Final Report - Corrections Required **Application No. ANEX-23-0014**

Report Date: 09/13/2024

Document Filename : Karman Line Addition No 6 - Annexation Plat_8-28-2024

ANNEXATION PLAT KARMAN LINE ADDITION NO. 6

SHEET 3-1

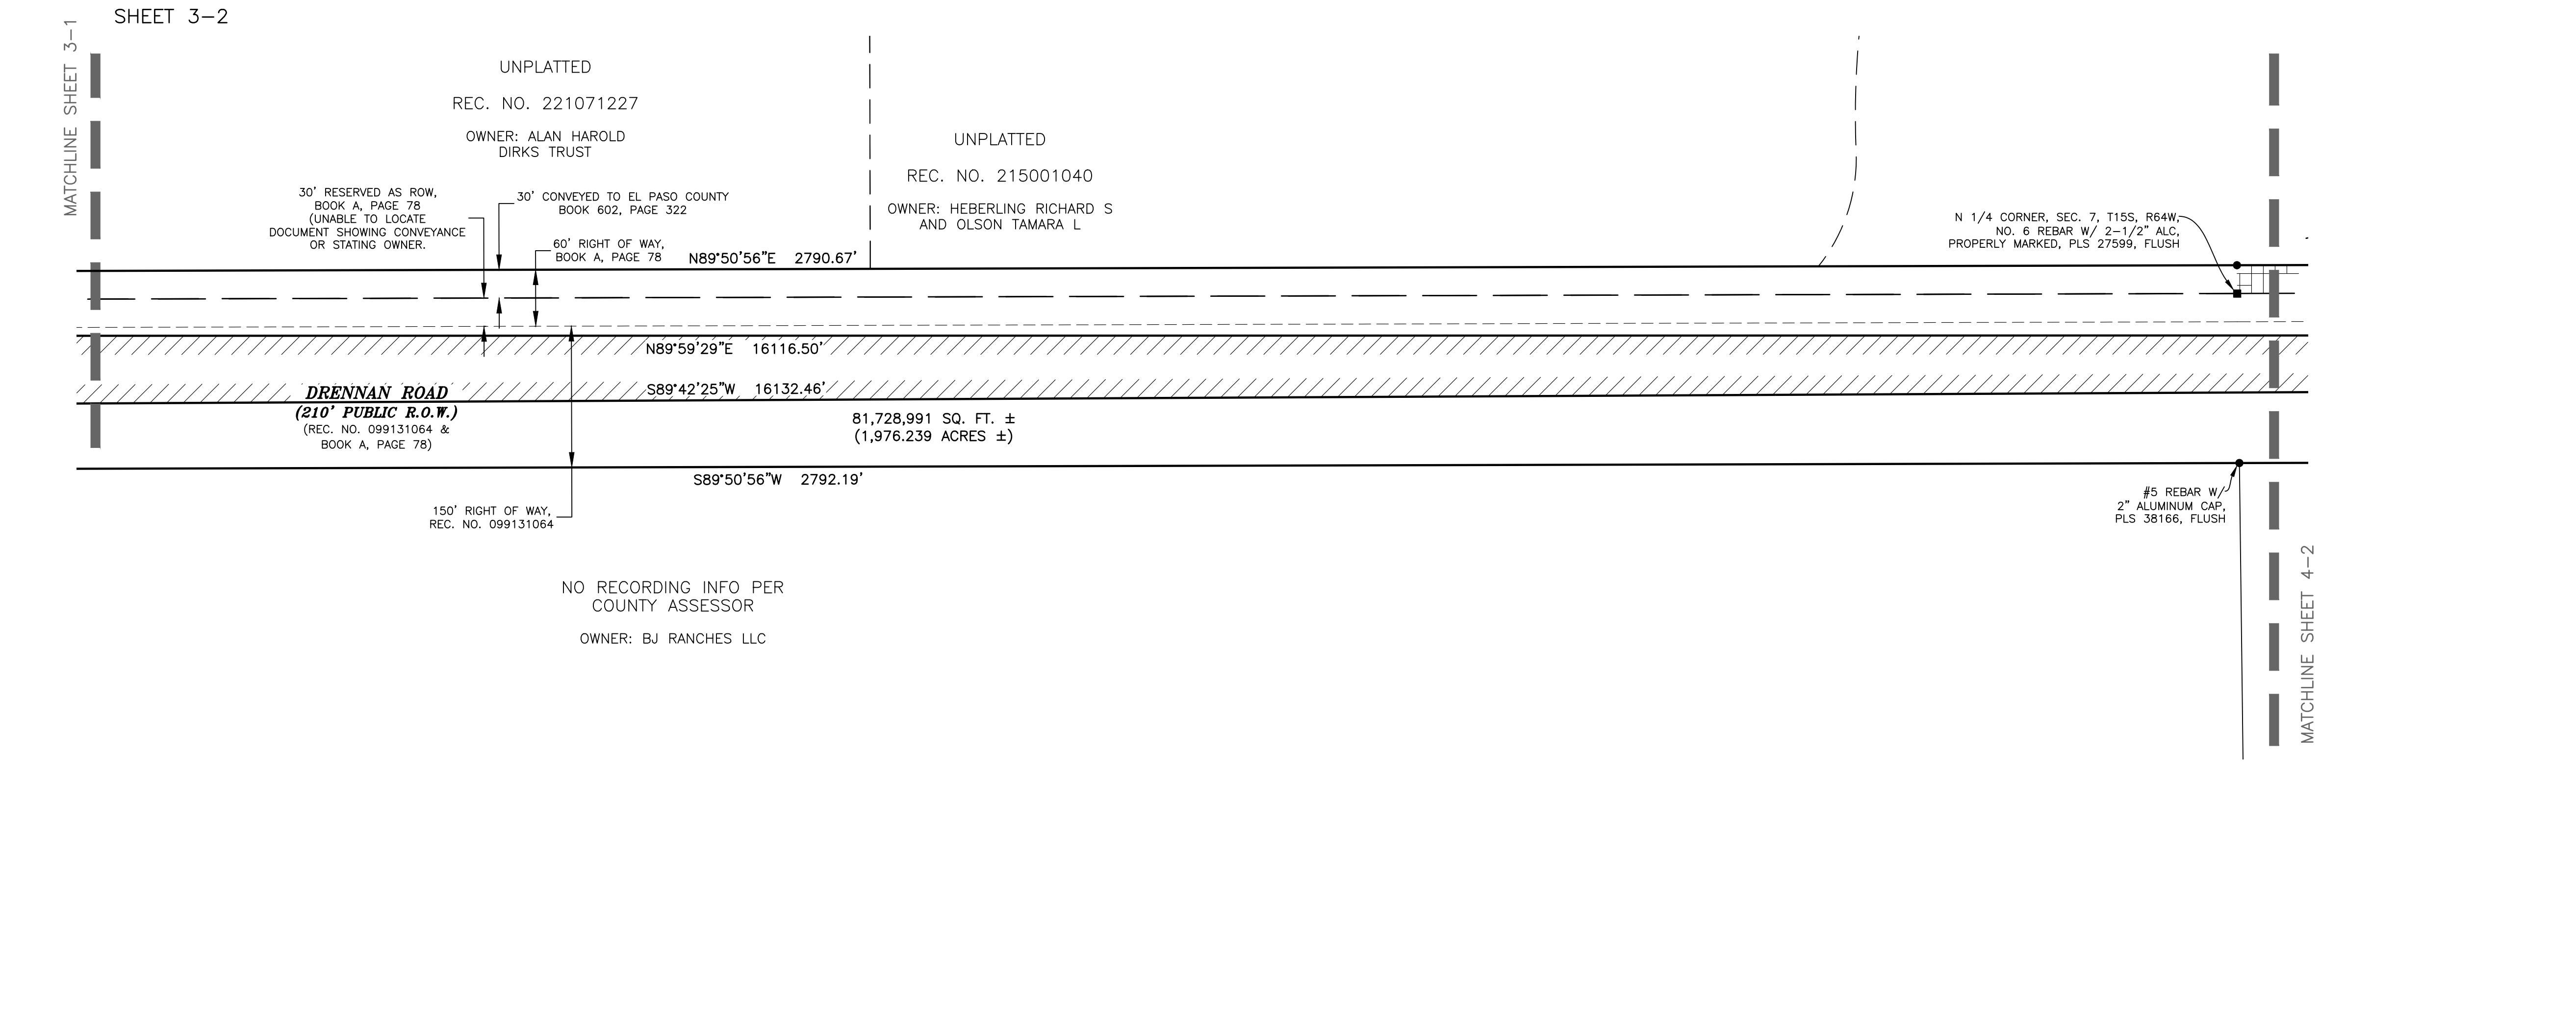
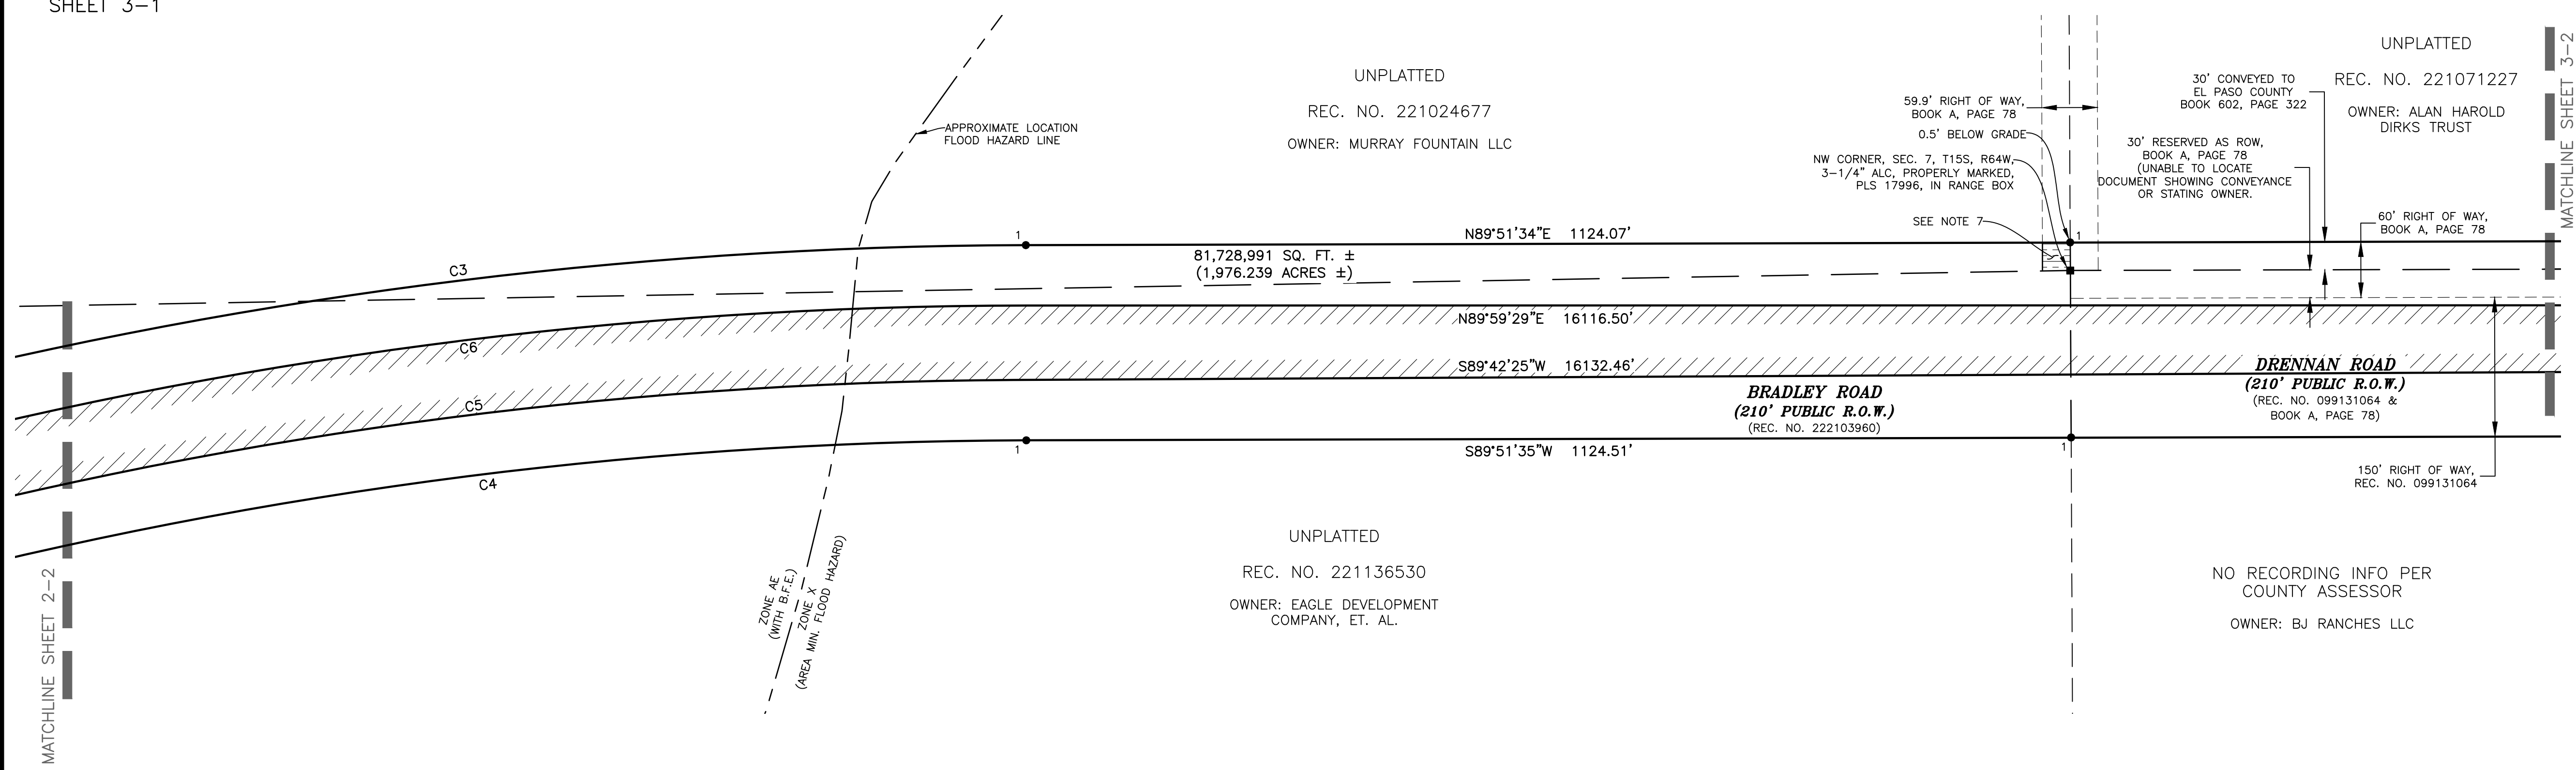
Comment ID	Page Reference	Reviewer : Department	Review Comments
103	3	Cory Sharp : Planning	please add the labels for the terminus of quitclaim deed reception no. 222103960 and the right-of-way document to the east
-	4	Cory Sharp : Planning	
104	4	Cory Sharp : Planning	there appears to be dirt access to the Goodrich property in this approximate location, is there a access easement? Please depict and label
105	4	Cory Sharp : Planning	please revise "dedicated" to the language from the document "deeded"? Dedication can only happen by plat
106	5	Cory Sharp : Planning	please depict and label the roadway going to the east

please note that this note is not on Addition No. 4 & 5 and depiction labels were only partially shown on Addition No. 4 & 5, if the area is still in question, the note and all the depiction needs to be added to Addition No. 4 & 5

If the 30' strip of right-of-way and 30' x 30' area are still in question and not part of El Paso County quitclaim to the City of Colorado Springs under reception no. 222103960 for the entire 210' width, it must be resolved prior to any approvals
